Our ref: 25_33194_P

Your ref: H13-0849-25

Site Location: Land off High Road Moulton
Spalding Lincolnshire PE12 6AL

Summary of Proposal: Change of Use to fishing and wildlife holiday lodges, erection of 5 modular holiday lodges with associated landscaping, planting and parking - Approved under H13-0683-20. Modification to Condition 2 to allow amendments to previously approved plans

DRAWING No.
005 P01

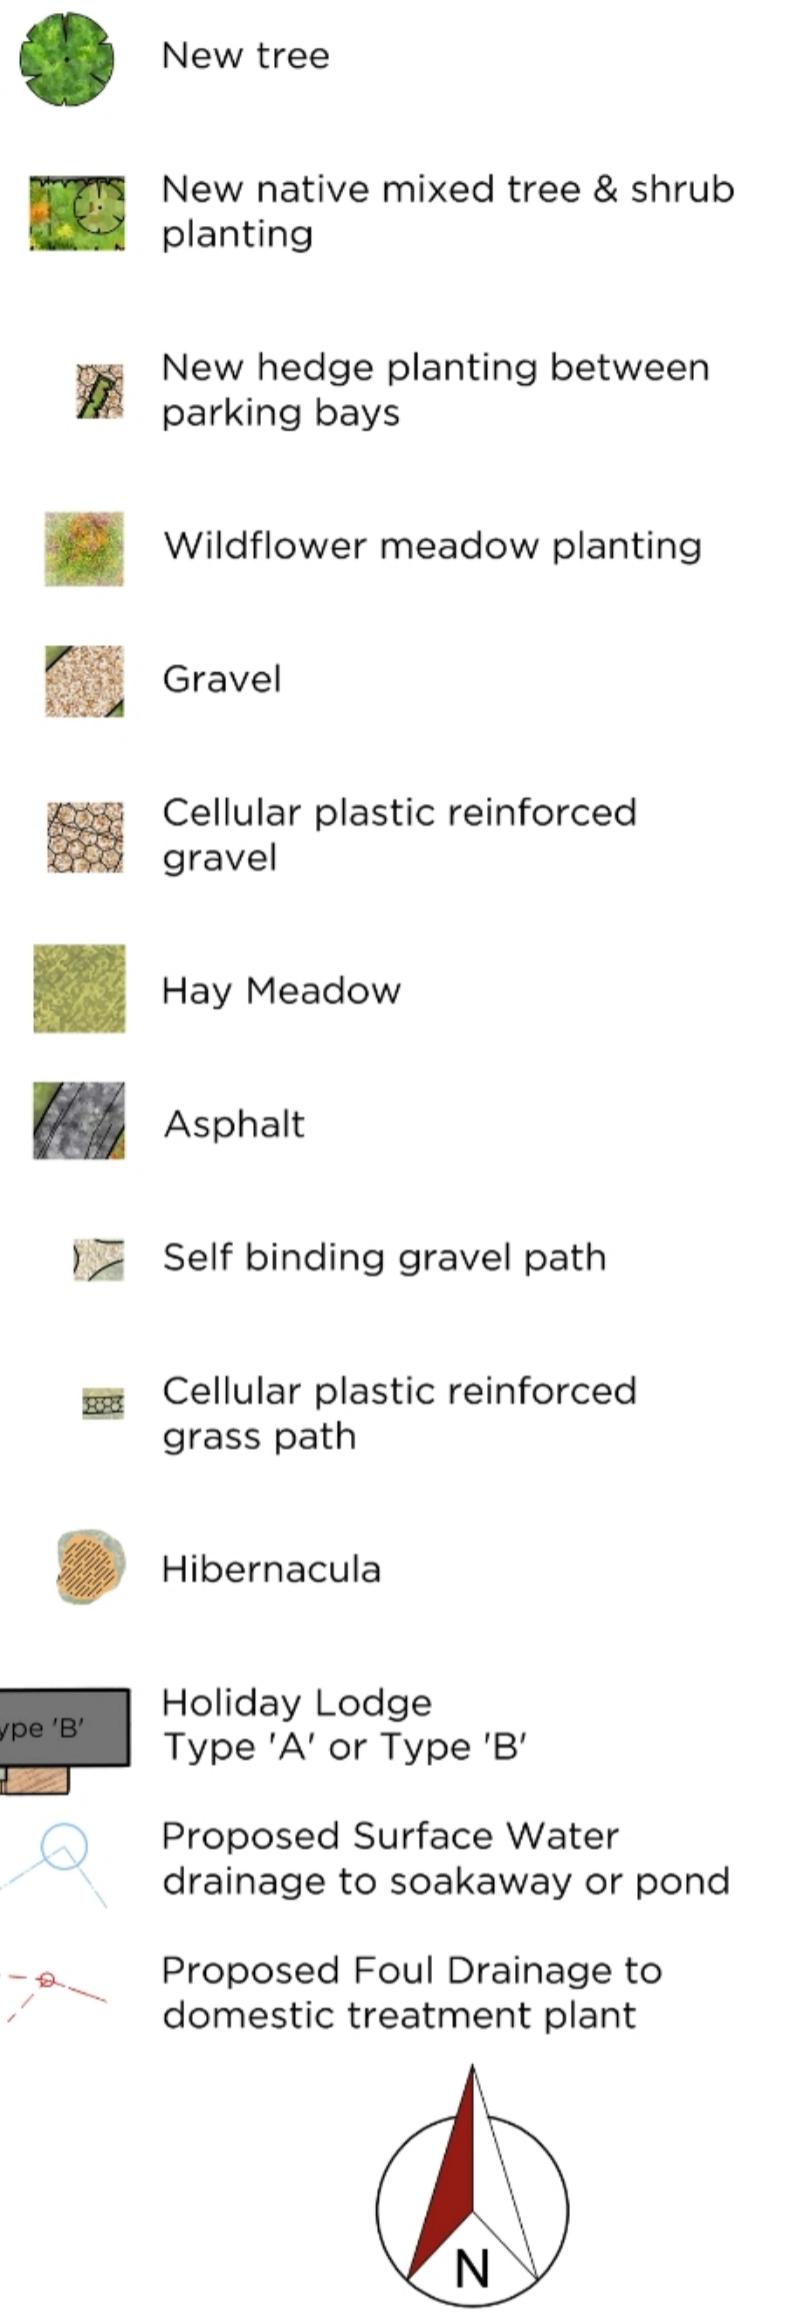
I note the presence of a watercourse which is not maintained by the Board (a riparian watercourse) within the southern site boundary and that works are proposed to alter this watercourse via the widening of the existing the access by 5 metres, as shown in drawing 'Proposed Site Layout 005 P01 Rev A (Seven 22 Architecture Ltd, 31/08/2025). To enable this proposal consent is required under Section 23 of the Land Drainage Act 1991 (and byelaw 4) and I recommend that the applicant contacts this office to make an application for this consent at their earliest convenience.
